**Arrangements for Handling Heritage Applications Direction 2021
& T&CP (Development Management Procedure) (England) Order 2015
& Planning (Listed Buildings & Conservation Areas) Regulations 1990**

**OAKWELL HALL, NUTTER LANE, BIRSTALL, BATLEY, WF17 9LG
Application Nos 2026/90398 & 2026/65/90398/E**

Historic England Advice

1 Proposed - South West Elevation 1

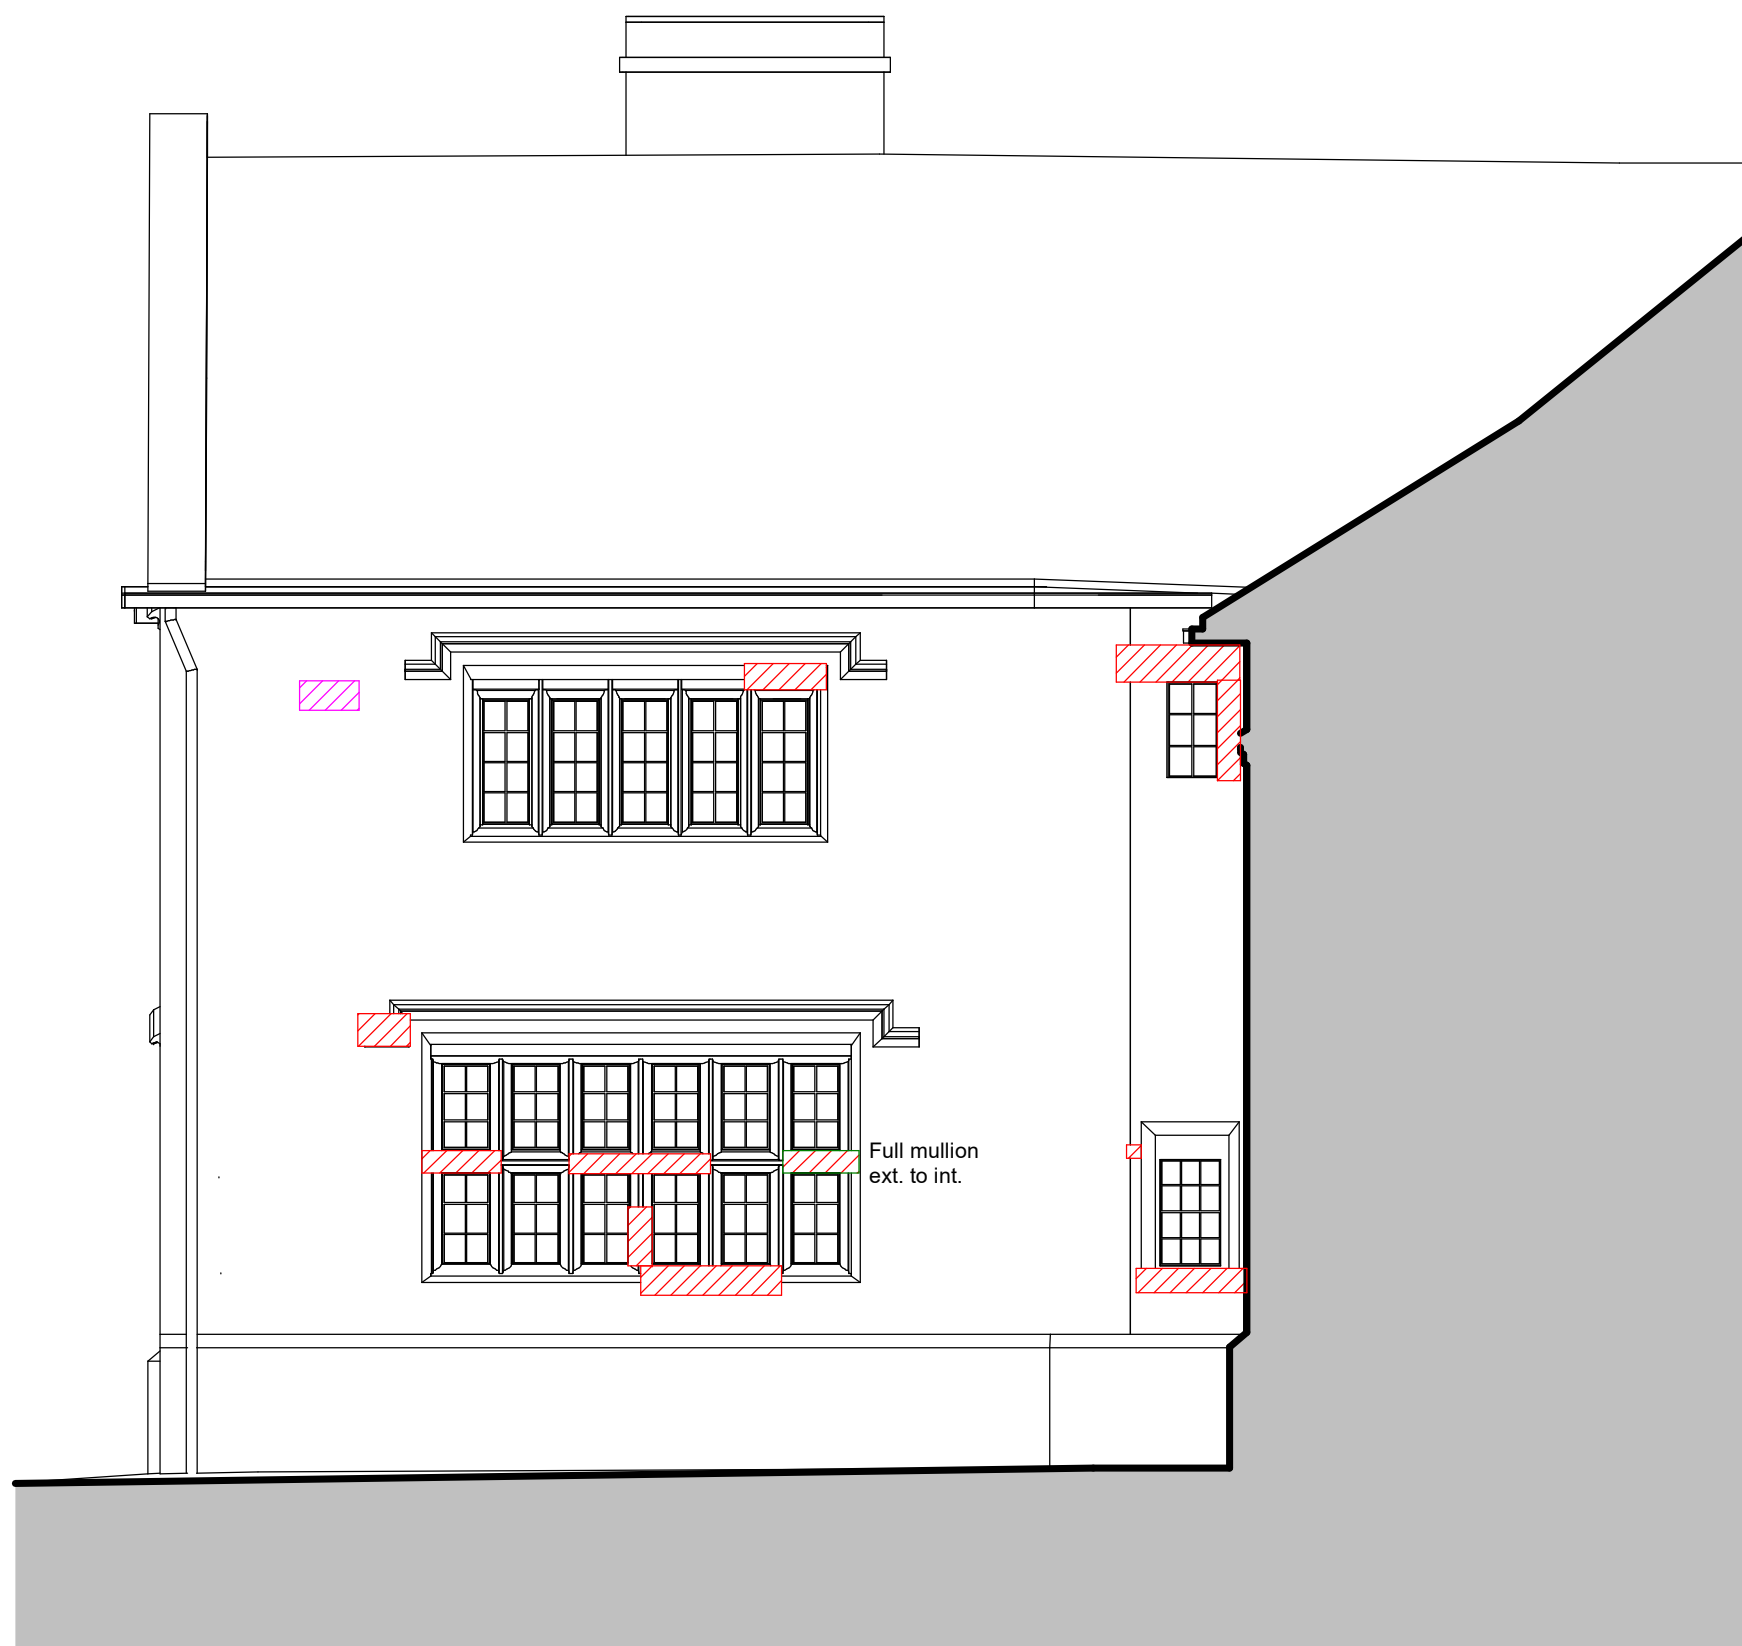
Largely the repairs to stone will have a small visual impact due to newly quarried and worked stone to be used to replace the historic stone. However, this will enable the building fabric to be more resistant to further decay and so this is largely balanced out

and is proposed to use stone from the original quarry sources.
